**Re: BP#2016-02662 593 Washington Avenue - Plan review comments**

I have completed the review of the above project for building code and have the following comments as noted on the attached files.

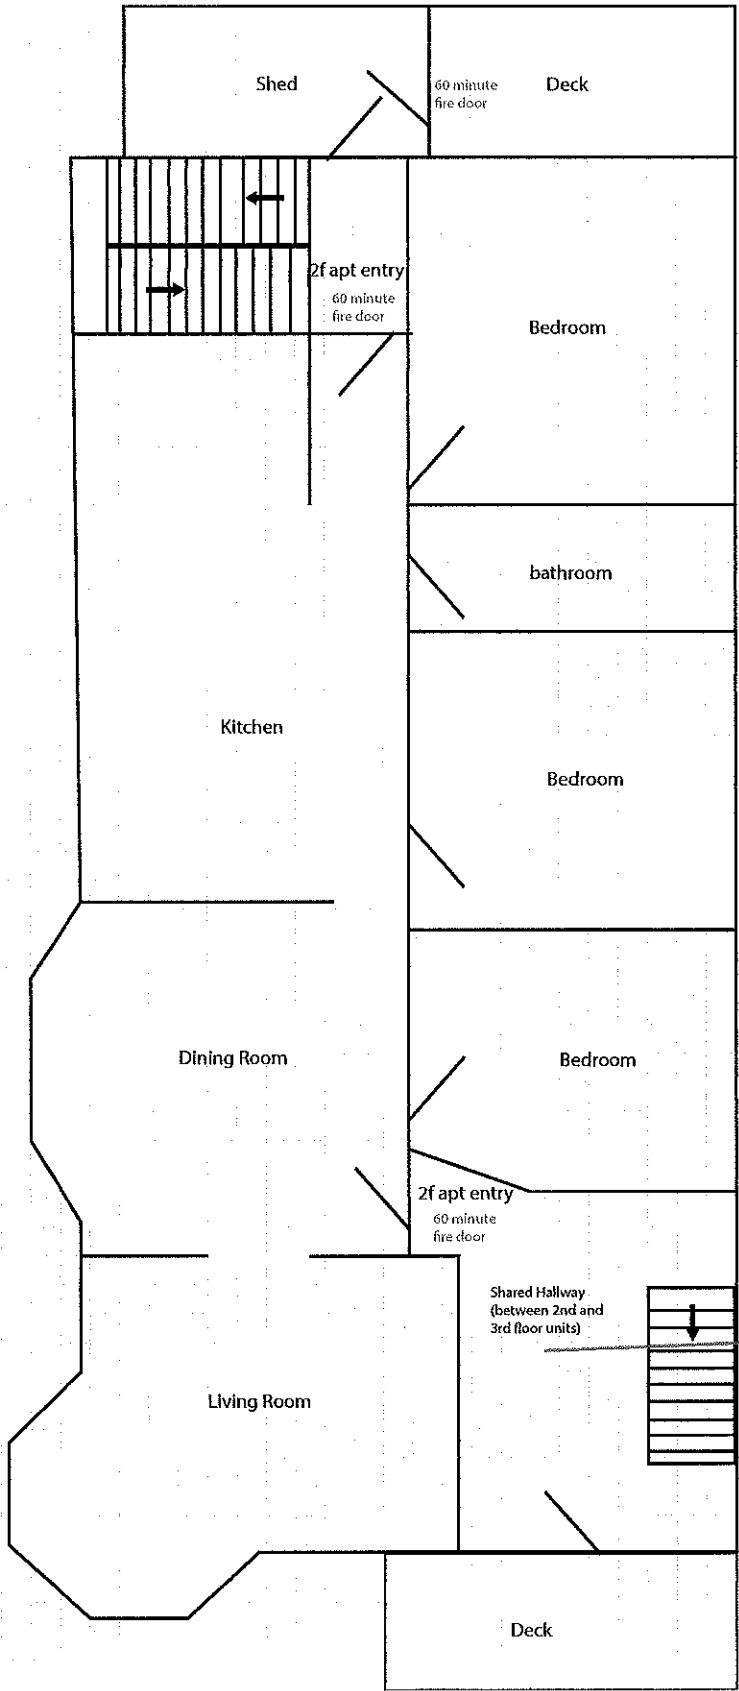
At this point, I need verification from the engineer and clarification that the floor/ceiling assembly is rated as well as the stair enclosure having the proper separation.

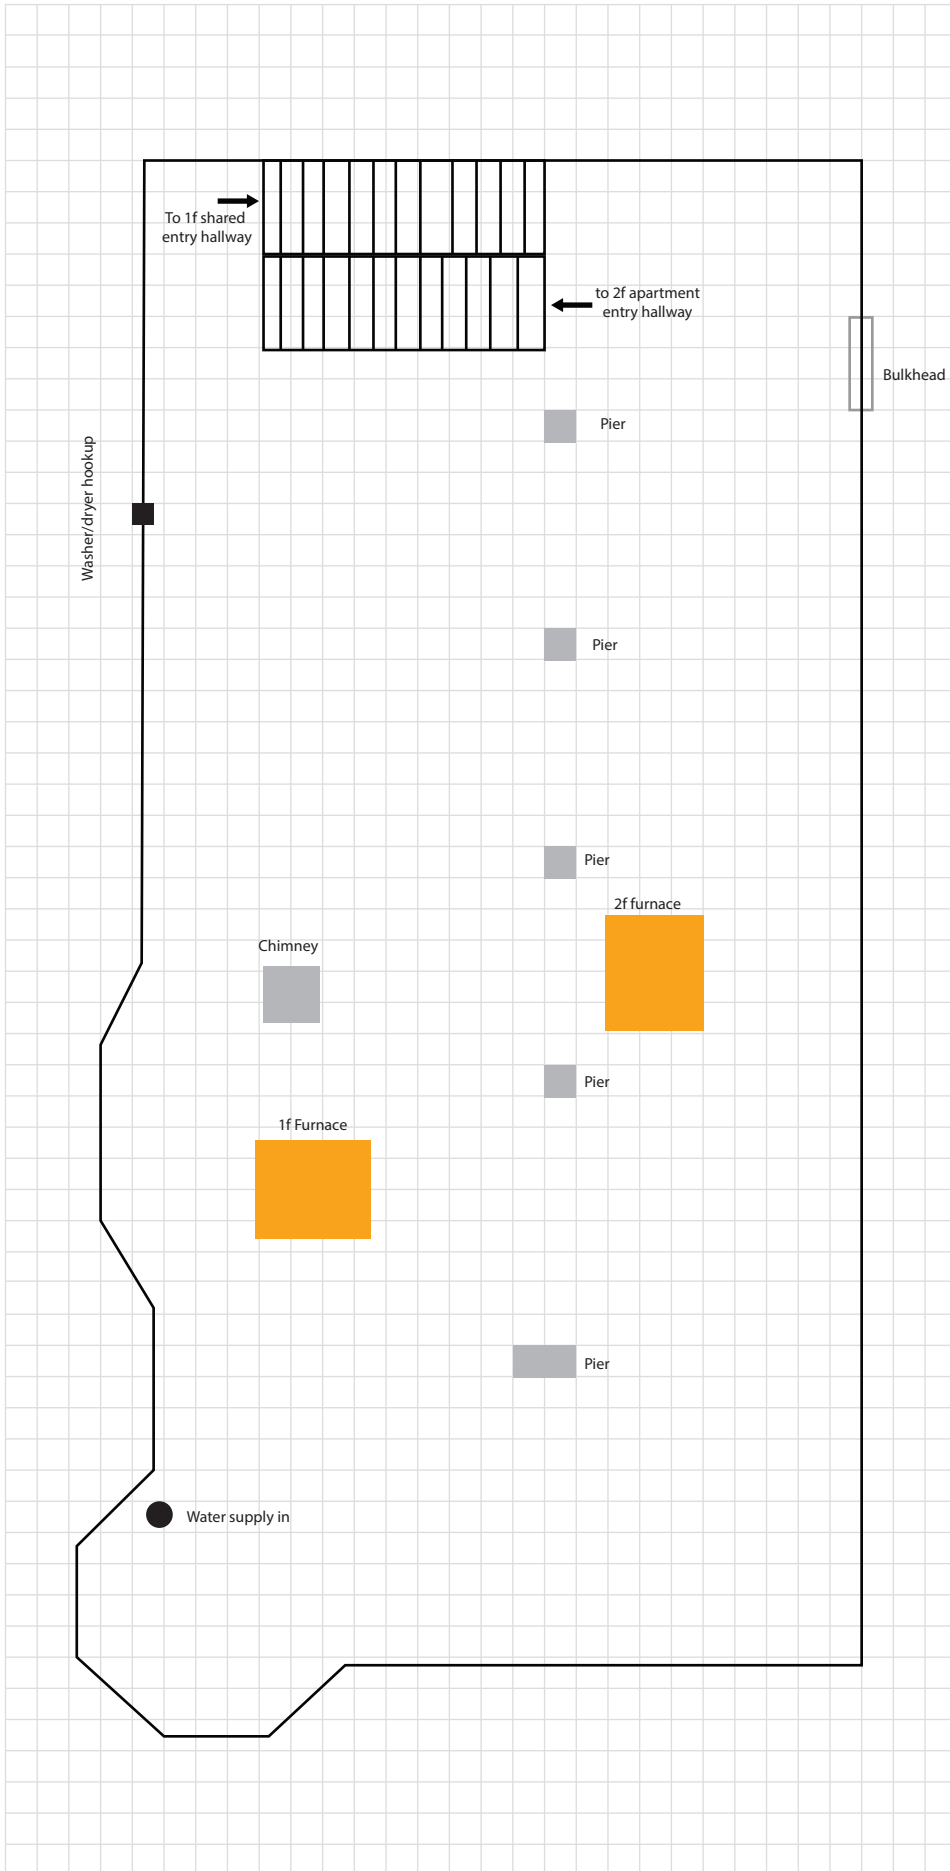
3. Tighten basement girder span: "The basement girder has a span of 10' at one location - one additional Lally Column should be installed such that the maximum space between supports of the main girder is 6'-6" "

4. Replace Hollow Columns with solid masonry posts or cement filled lally columns: "Hollow metal lally columns should be replaced with lally columns that are concrete filled or solid masonry posts, timber posts may also be used if sized appropriately, we did not size any timber posts for this use. This is for fire performance rather than strength."
